Engineers Comments Regarding Surface Water Drainage

Application No: M/17/21/HH
Registered: 18th February 2021
Site Address: 14 North Avenue South Ancton Middleton-On-Sea PO22 6HE
Grid Reference: 498016 100294
Description of Works: Single storey side and rear extensions.

Proposed Ground Floor Plan

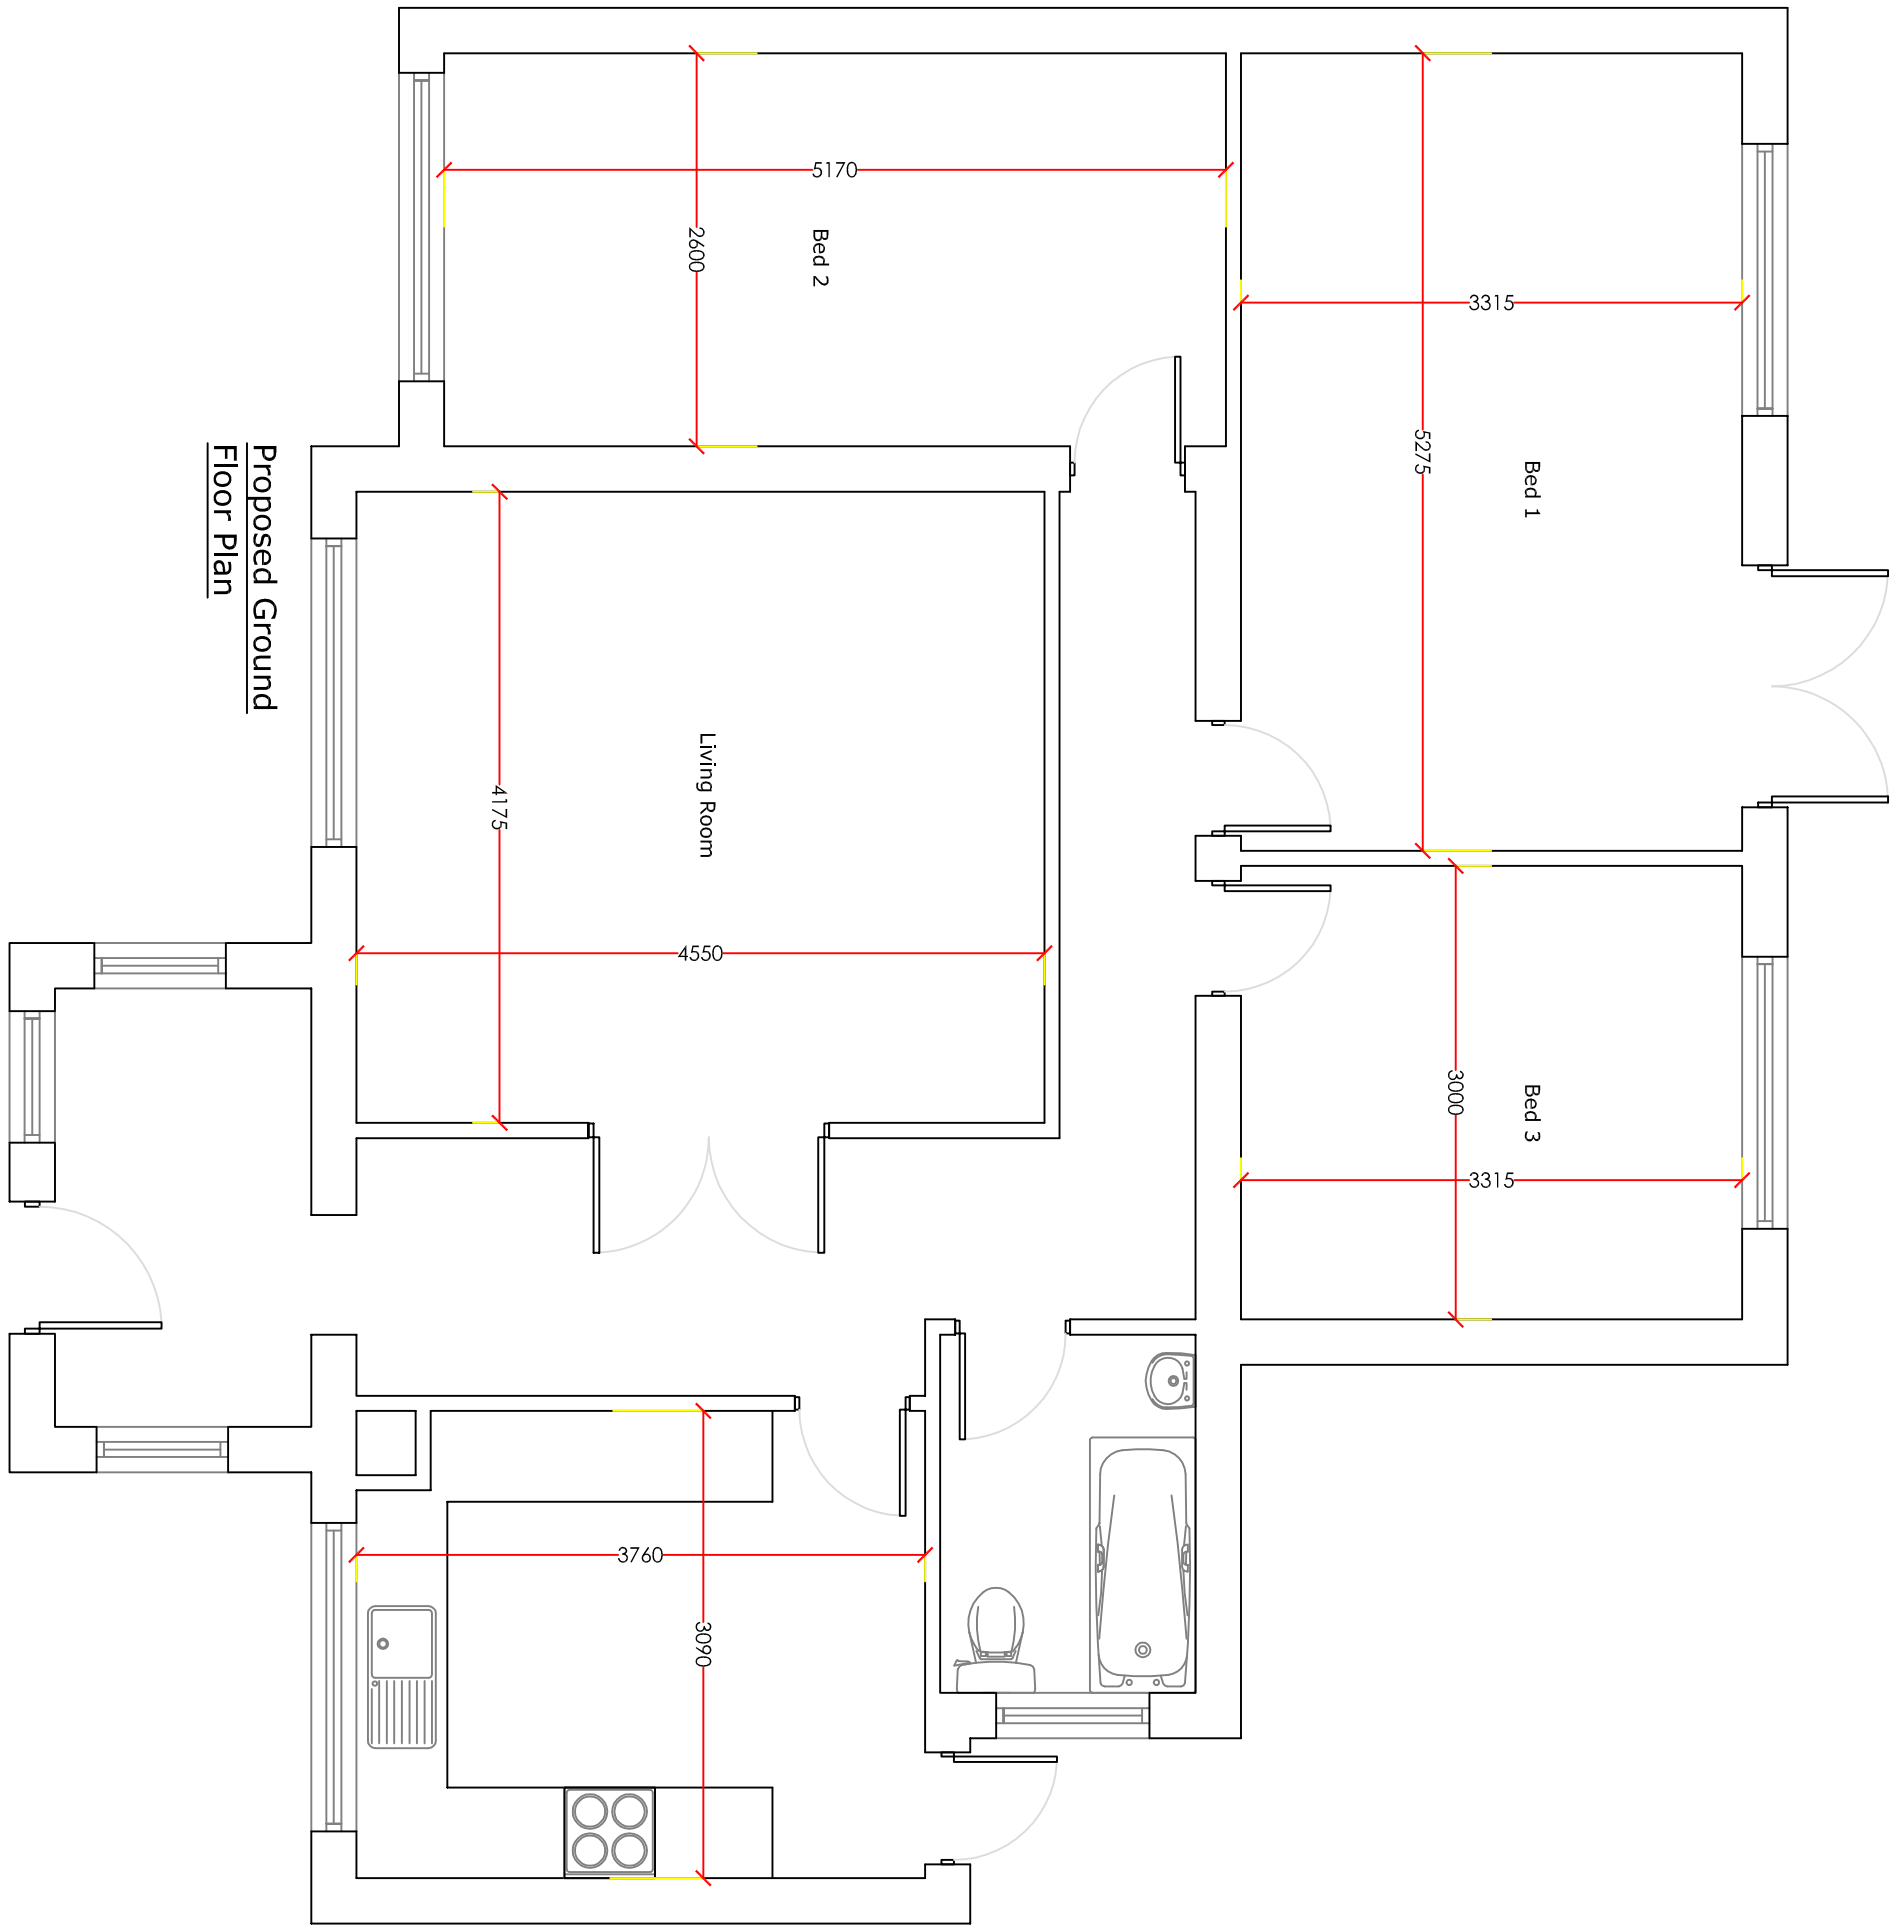
According to our mapping there may also be a foul water sewer running through the rear garden in the location of the proposed extension. Southern Water should be consulted regarding the location of this sewer and any easements, diversions, or build over agreements that may be required.
